Rezoning Transportation Analysis

Petition Number: 2021-163

Date	Description
08-26-21	First Review (LH)
09-23-21	Second Review (BKB)

2 - 7TH STREET SECTION B (W/O RIDESHARE/DROPOFF)  
SECTION

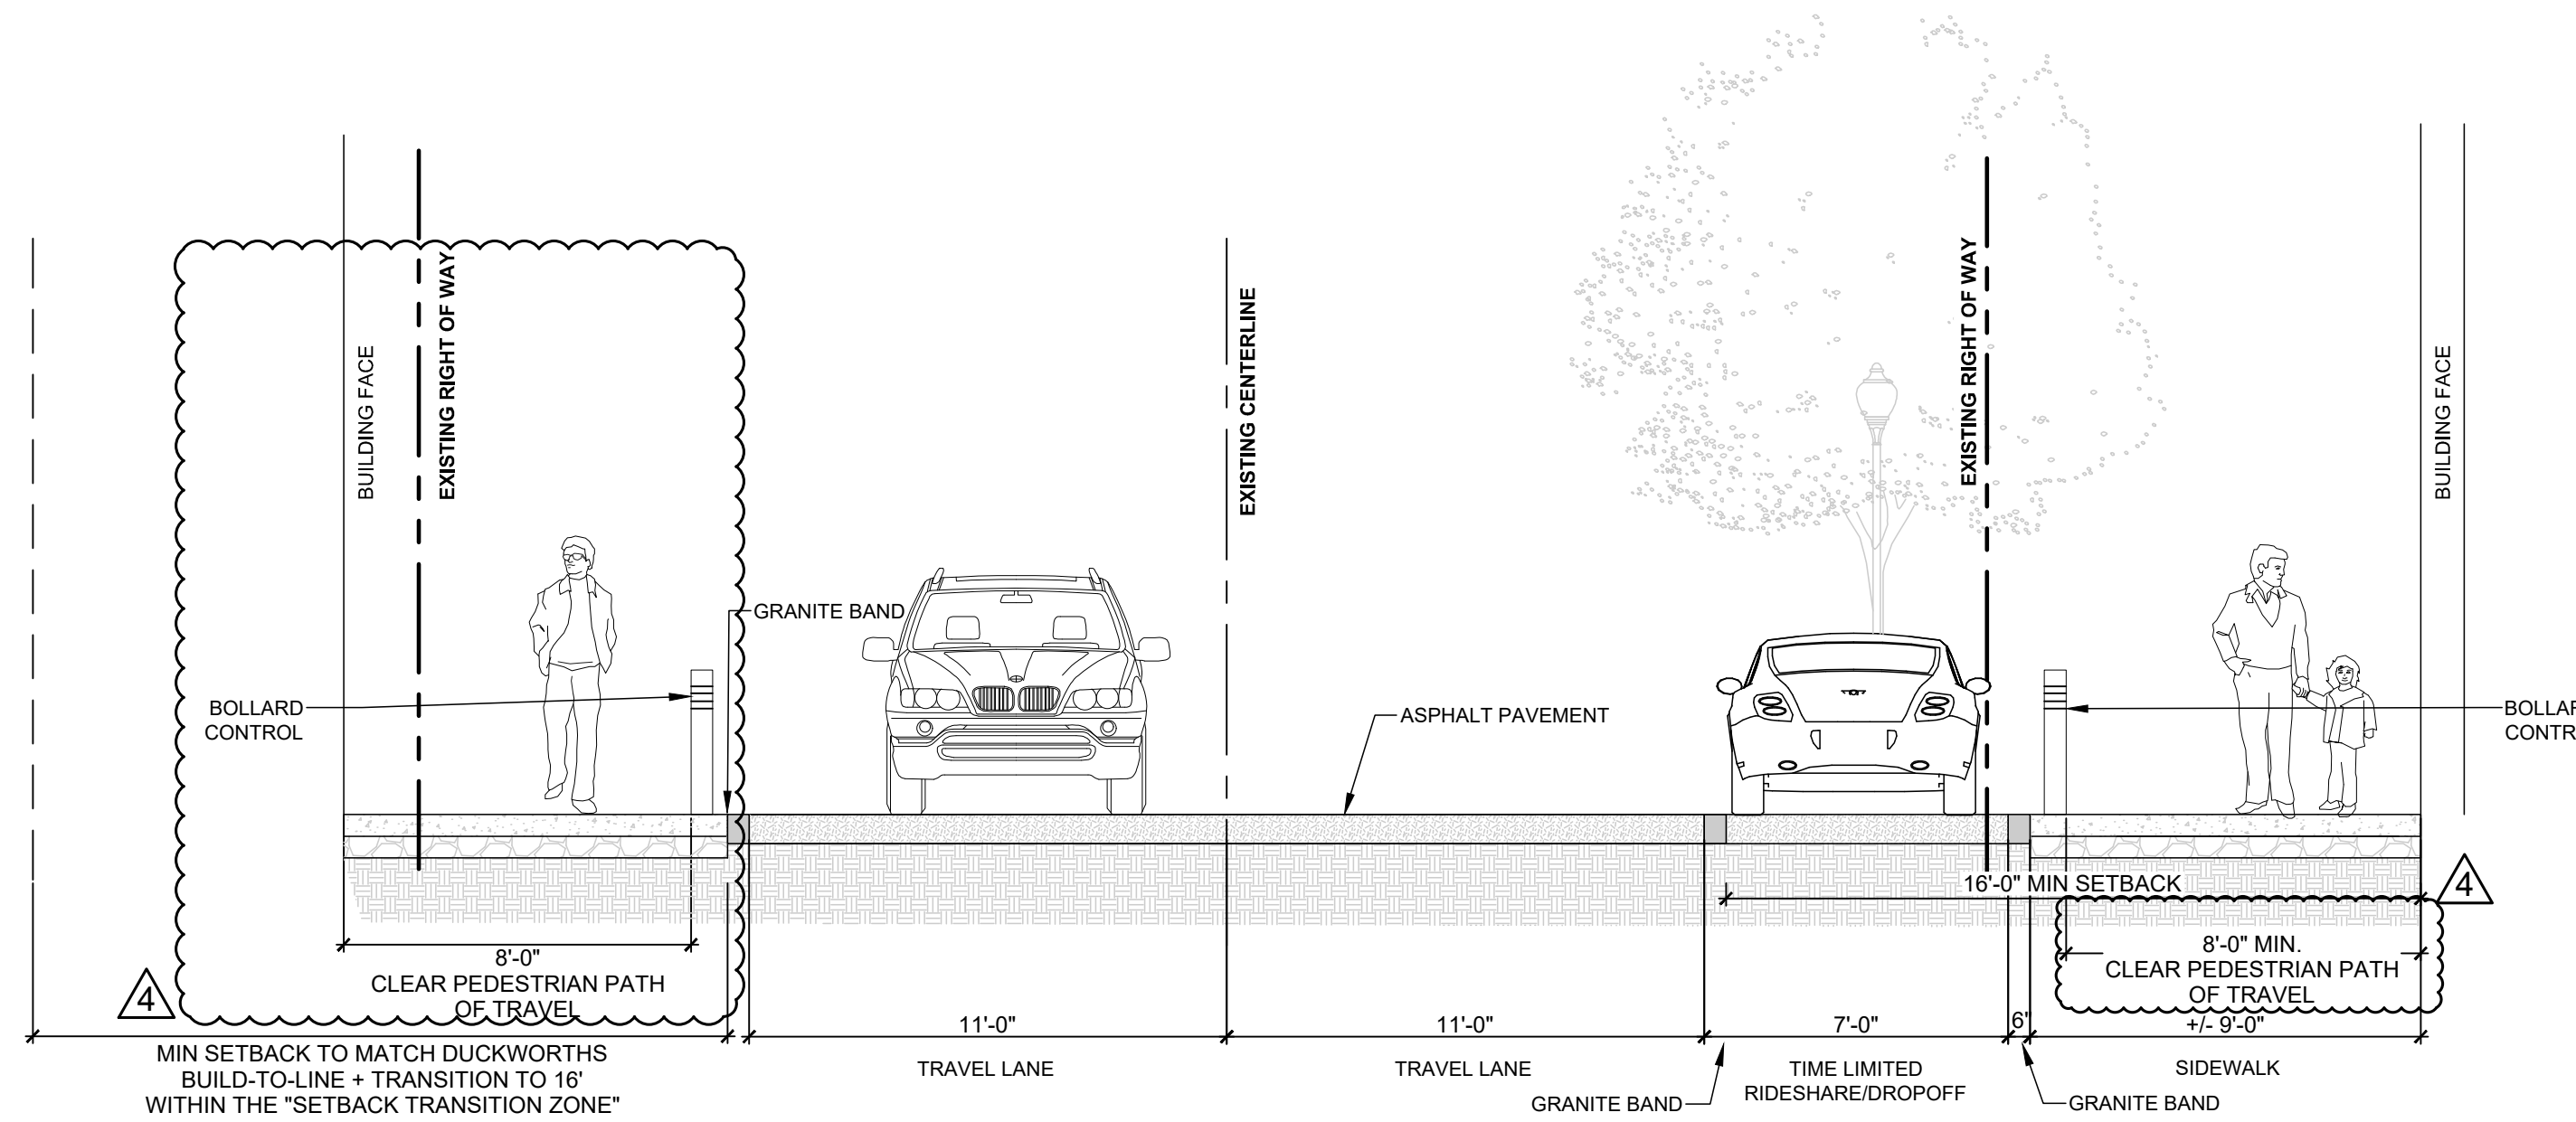
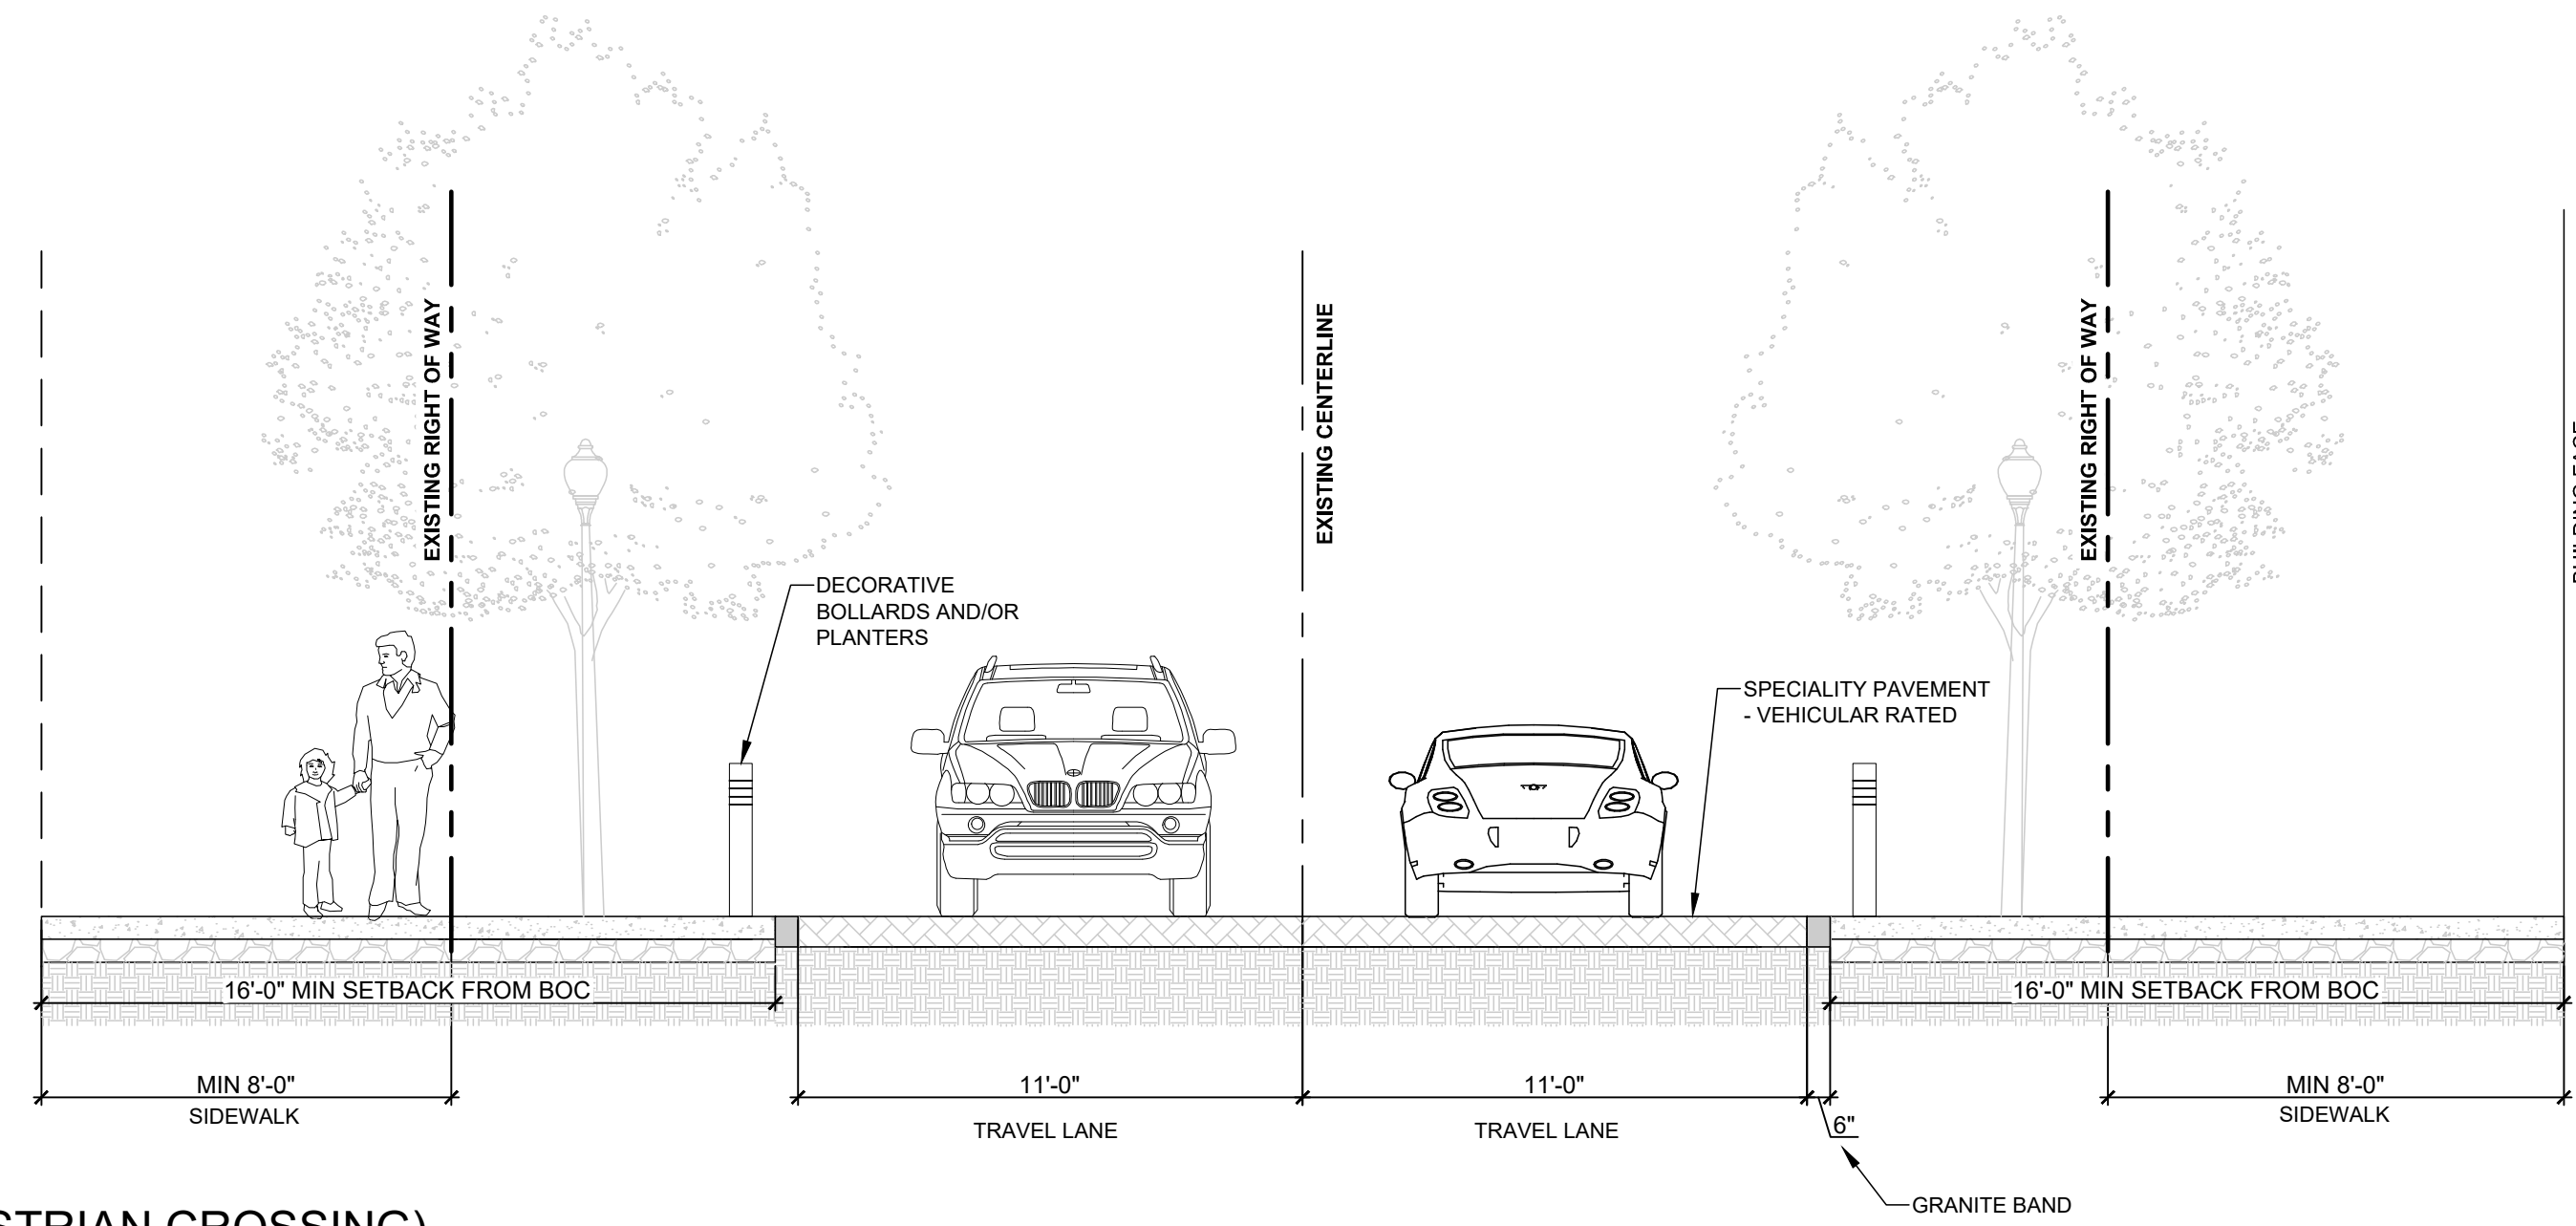
a. **Travel Lanes:** 10-foot travel lanes are not suitable for shuttles that would frequent the hotel or a GATS bus if 7th Street was used as a detour. Update travel lane adjacent to hotel to 10 foot, 6 inches minimum width. If using vertical curb, adjust for 11-foot travel lanes.

- b. ~~Curbless Street w/Bollards~~: Add a conditional note that states to confirm that PROWAG and drainage adjustments are accounted for during permitting. Place bollards as far away from travel lane as possible within the 1 foot, 6-inch flush granite curb. Show limits of bollards on site plan.

2 - 6TH ST. STREET SECTION E  
SECTION

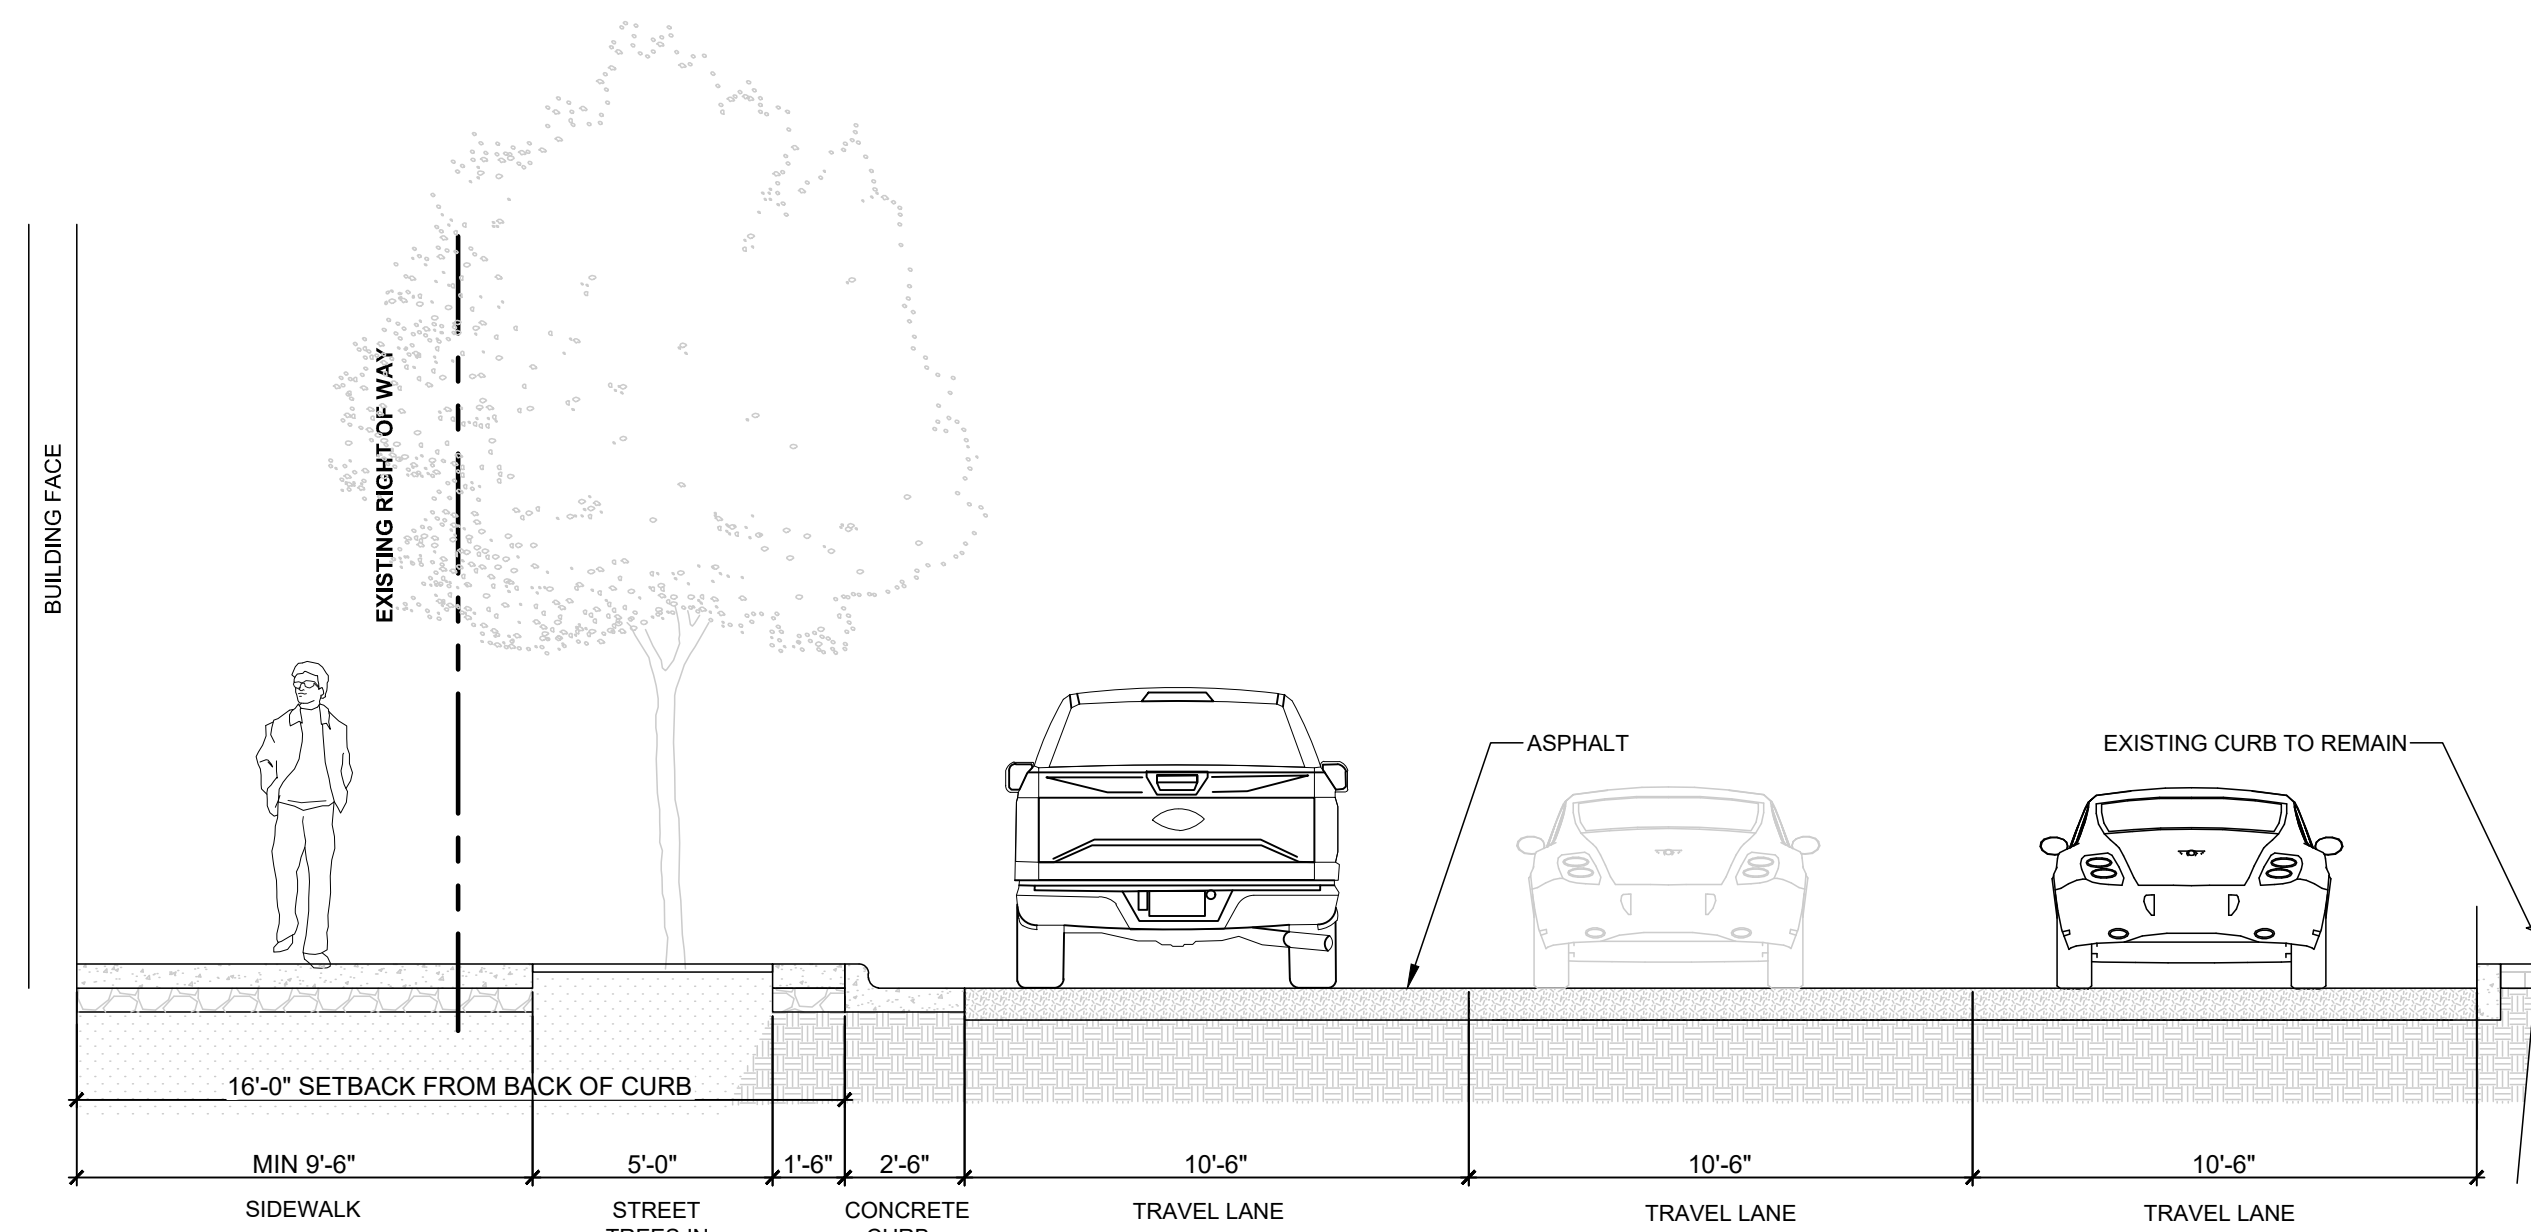
4. **6th Street Cross-Section:**
 - a. ~~**New Cross-Section:** Include a second cross-section that shows a consistent 10' cycle track width and 11' travel lanes.~~
 - b. ~~**Right of Way:** Show right of way line on cross-section and ensure building face is outside of right of way.~~
 - c. **Pedestrian Pathway:** Update site plan and conditional notes to show minimum 12-foot sidewalk width. **Updated per Site Plan Dated 09-13-2021:** 8-foot minimum sidewalk consistent with all other streetscape improvements in area. Verify that 8-foot sidewalk is achieved as it appears to be less than that in an area below the dimension on the site plan:

d. **Cycle Track:** Update site plan and conditional notes to show the correct and varied dimensions, as shown below. Add a conditional note that vertical curb and curb and gutter are both acceptable adjacent to the cycle track, but the gutter width cannot be used to account for the 10' cycle track width. Add a conditional note that nonstandard material is allowed in median between cycle track and vehicle travel lanes, but an encroachment permit will be required. Additionally, provide a conditional note that specifies the commitment of constructing the cycle track on 6th Street.

e. **Dimensions:** Adjust dimensions as shown below:
